East Midlands Gateway - Deadline 5 Submissions on behalf of Protect Diseworth

This document comprises the D5 submissions on behalf of PD. The response primarily relates to the Applicant responses to ExQ2 (as submitted at D4) but also include related submissions on Traffic and Transport following direct engagement with the Applicant and as previously referred to within PD's Written Summary of Verbal Representations as submitted at D4.

Drawing file: published-documents / BC0410001-001269-DCO 2.16 Community Park Plan Deadline 4.pdf

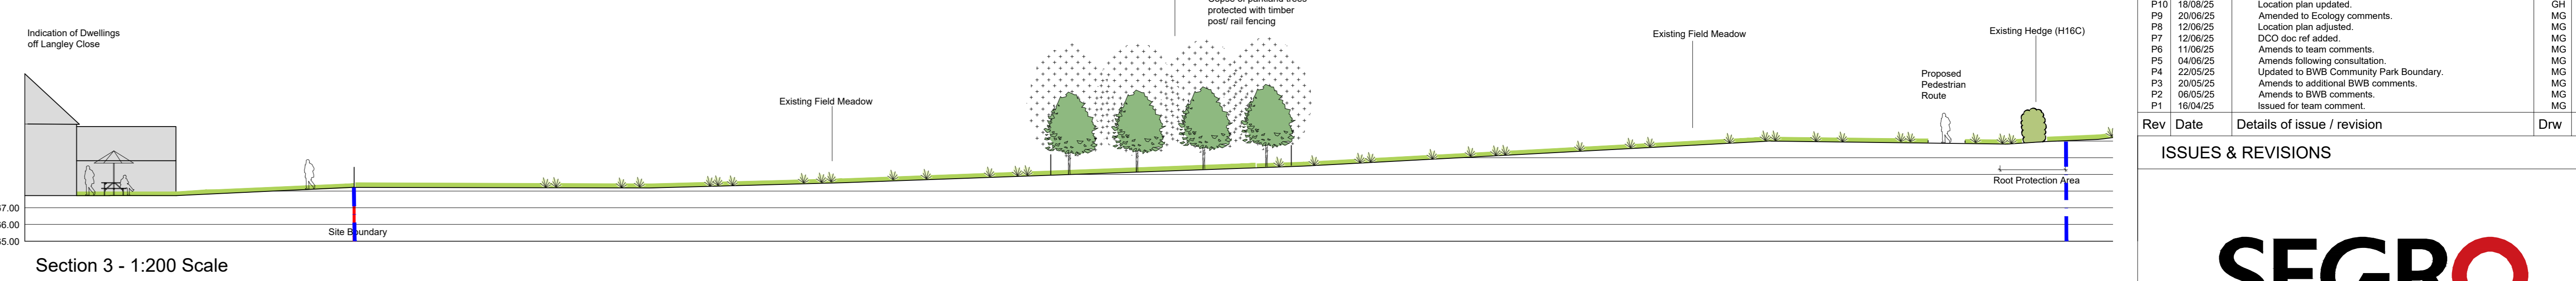
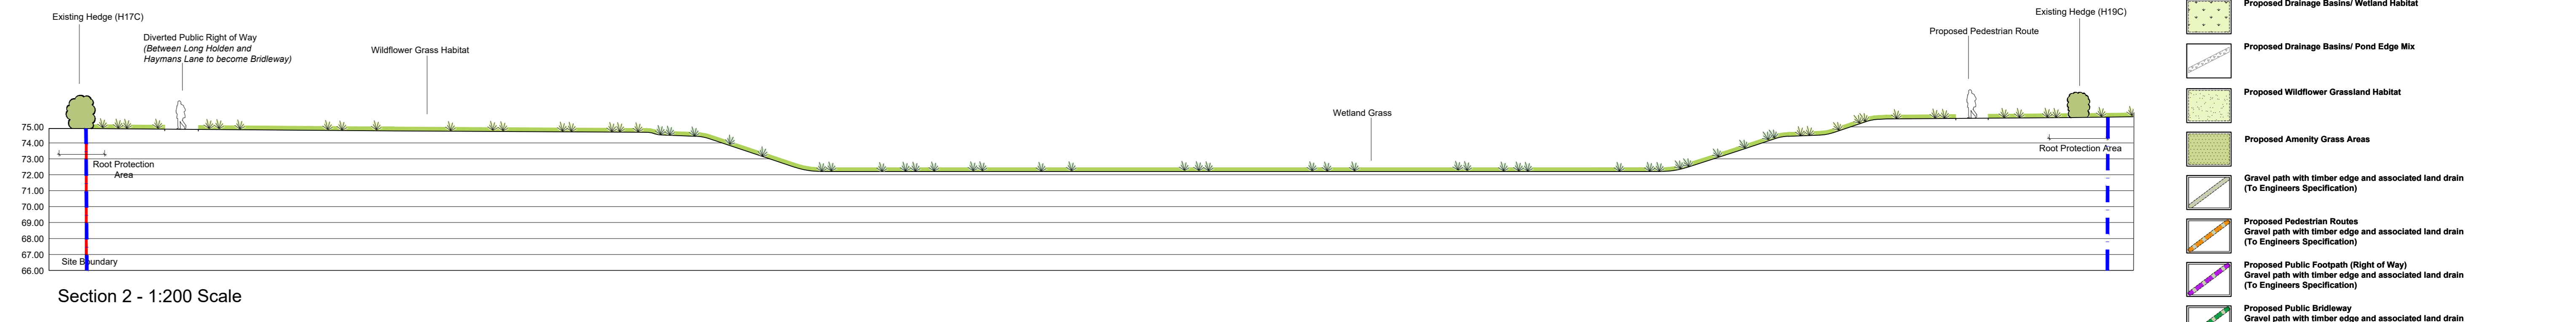
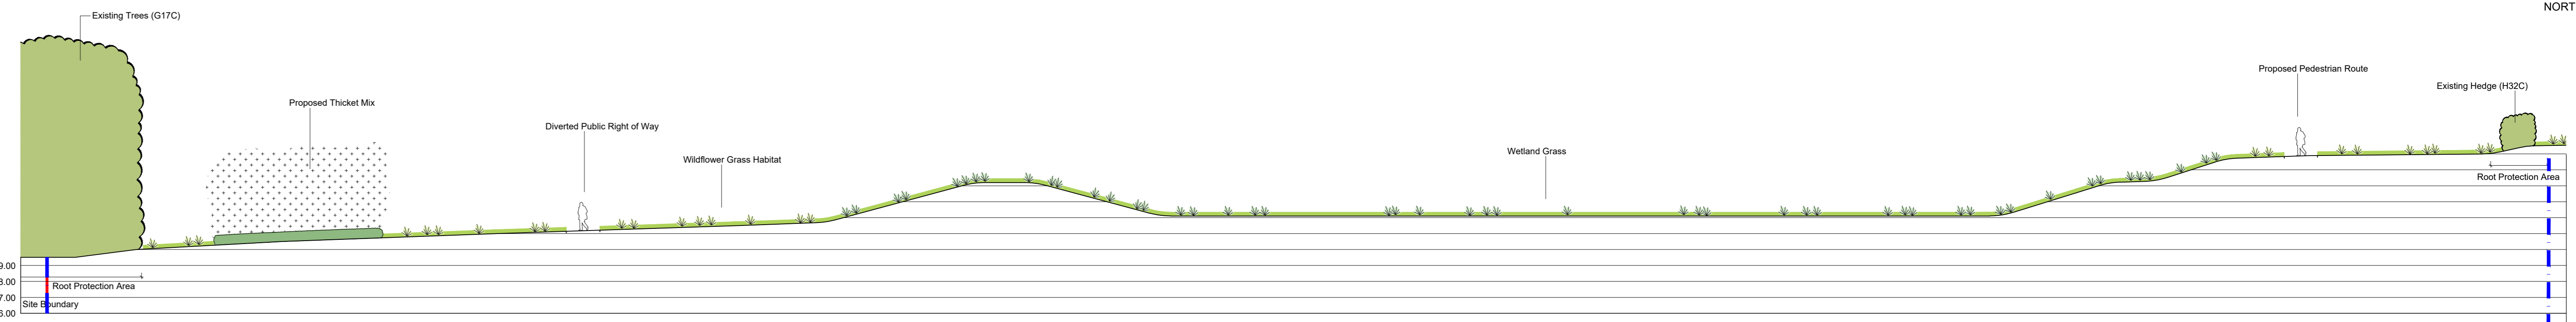
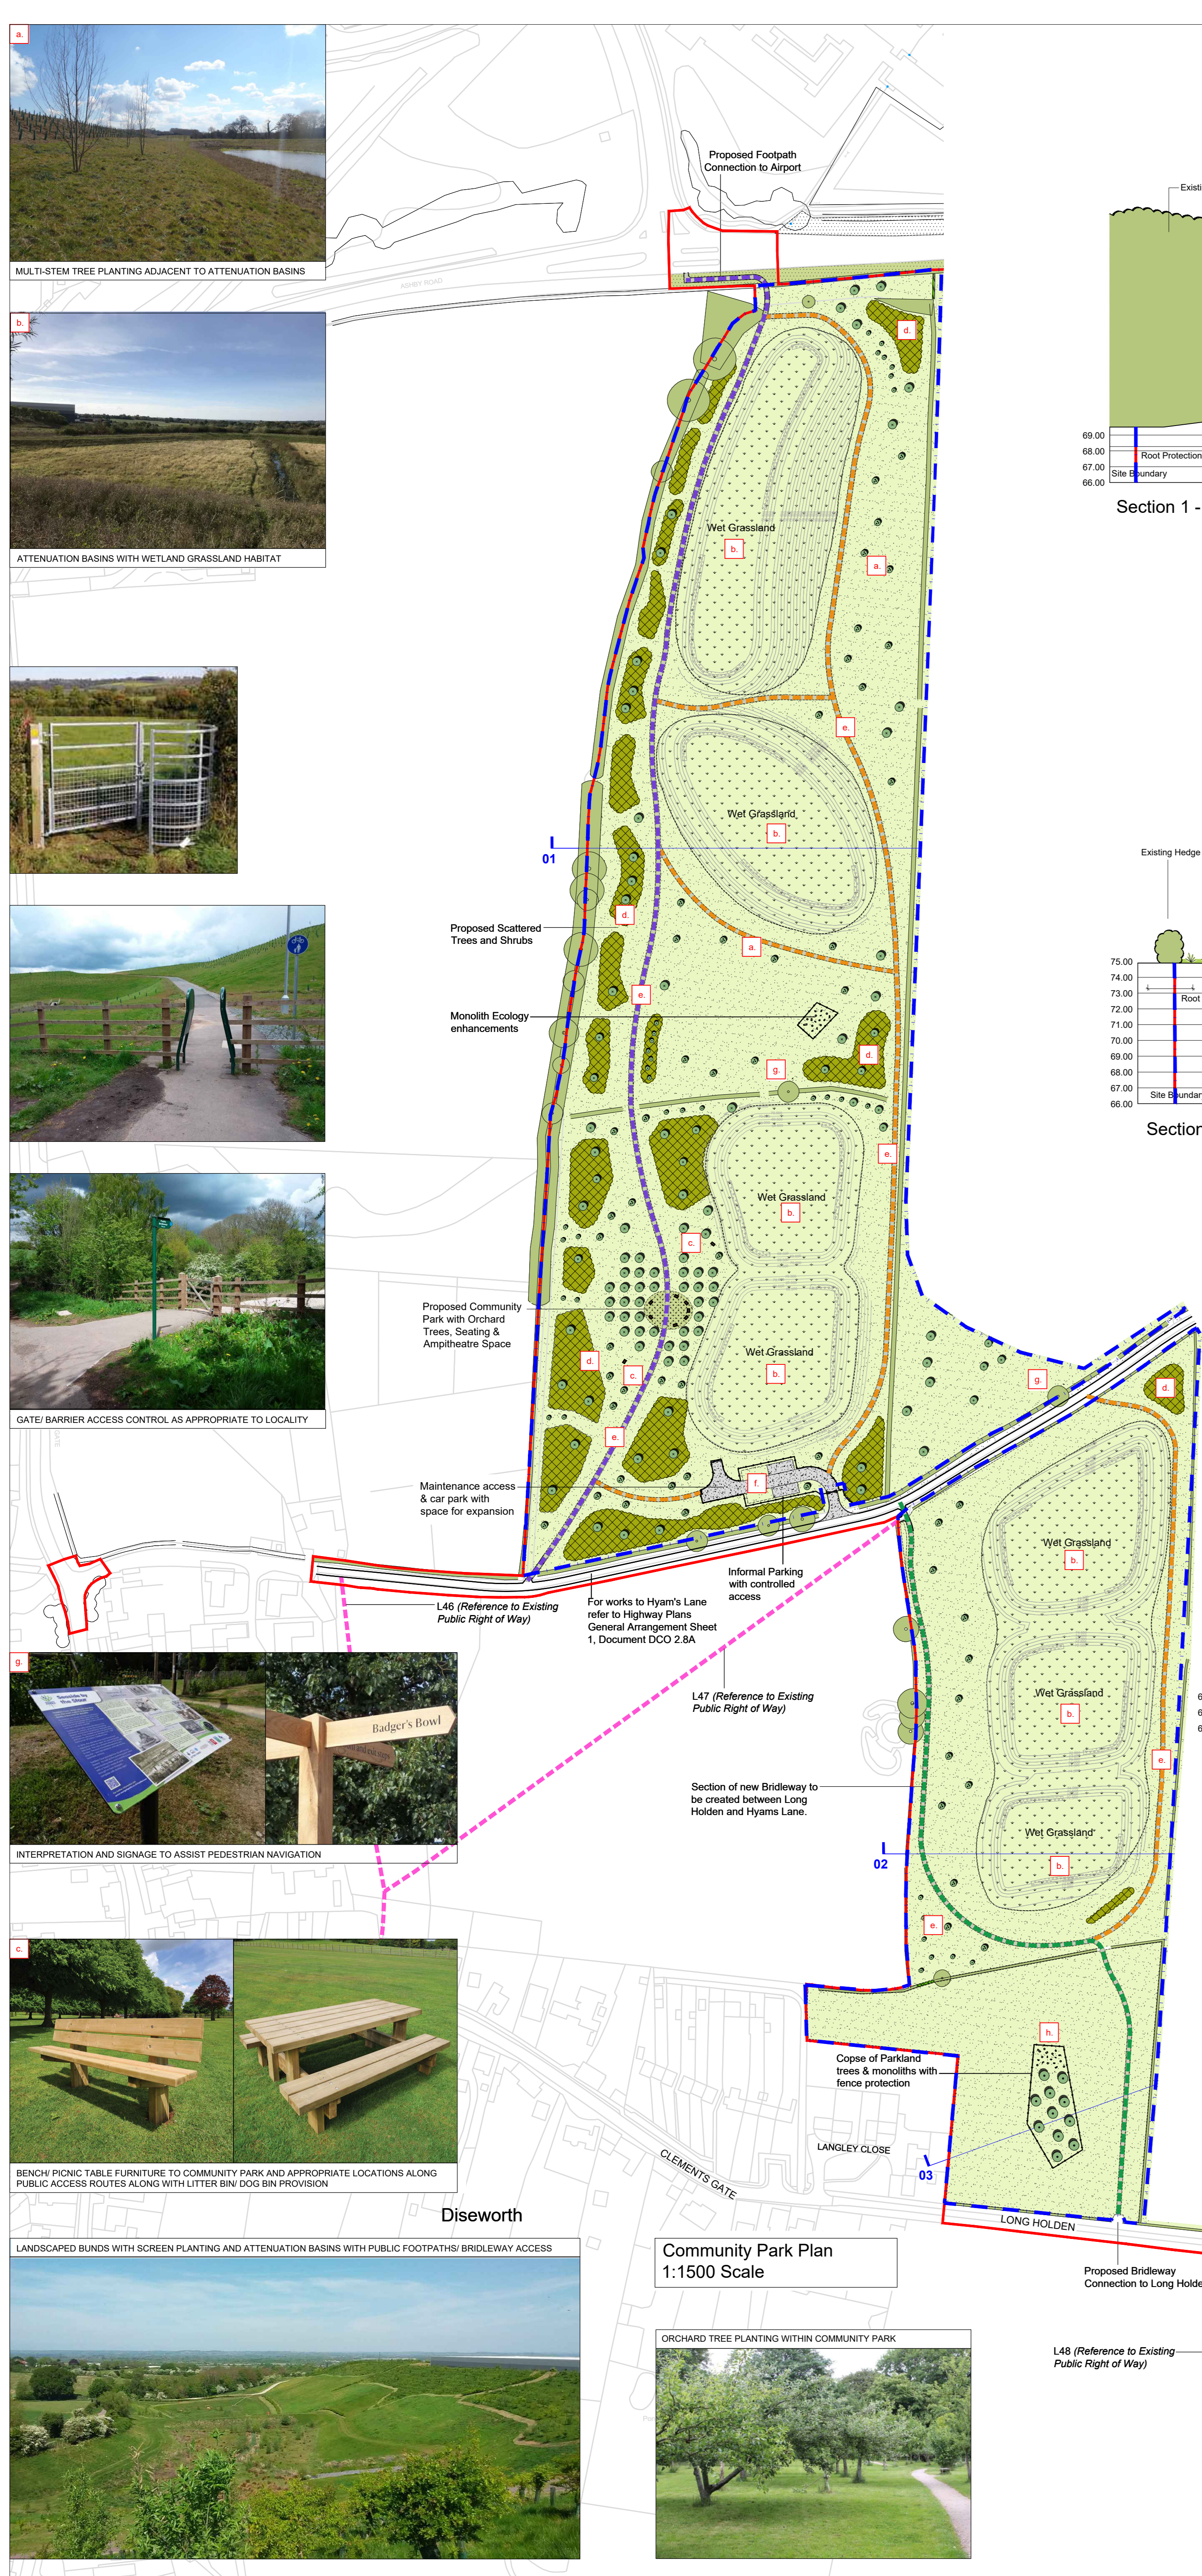
Q1.2.1 (Community Park) – PD note the Applicant's comments on this question and would offer the following additional comments. As such, PD consider that Accessibility should be demonstrated across the 'community park' as a whole, including access to viewing areas, landscaped spaces, biodiversity features and other attractions, rather than only along designated Rights of Way.

PD consider that the steeper gradients are being driven by the need to accommodating large attenuation basins required for the development's Sustainable Drainage System. This reinforces concerns that the site's primary function is drainage infrastructure rather than recreational open space, with accessibility necessarily constrained by engineering requirements.

In PD's view, the Community Park was designed as an area of mitigation for the development, rather than a functional and accessible open space, that could be actively used by the community, which is why these issues of conflict between public use and delivery of mitigation have arisen. Furthermore, the Applicant fails to address maintenance issues, including areas of standing water, and muddy areas, that may impede access during inclement weather. This will have direct implications for people with mobility issues and simply highlighting acceptable gradients does not demonstrate that the scheme delivers inclusive access in accordance with good design principles.

Q1.2.2 (Community Park Plan) – PD have reviewed the updated 'Community Park Plan and supplemental Community Park Typologies Plan (attached at Annex 1C) and would offer the following additional comments.

- As already noted above the 'Community Park' will primarily exist and function as a SuDS drainage system, with the bulk of land area assigned to large drainage basins which are

inaccessible to humans (and a safety risk for children). PD consider that public access was an ‘afterthought.’

- *In this respect, the current design of the Community Park is considered to conflict with Paragraphs 96 (b) and 103 of the NPPF, which collectively seek to encourage access to ‘high quality open spaces’ which encourage the active and continual use of public areas.*
- *If most of the ‘park’ consists of attenuation basins that are inaccessible or fenced off, there is a legitimate question whether it can properly be described as community open space. The applicant should distinguish between land provided primarily as engineering infrastructure/mitigation and land providing genuine recreational benefit.*
- *The Applicant should explain how this drainage system will be managed, including regimes of inspection and maintenance, and how these are secured in the DCO. Both the NPPF and national SuDS policy require that drainage systems remain effective for the lifetime of the development.*
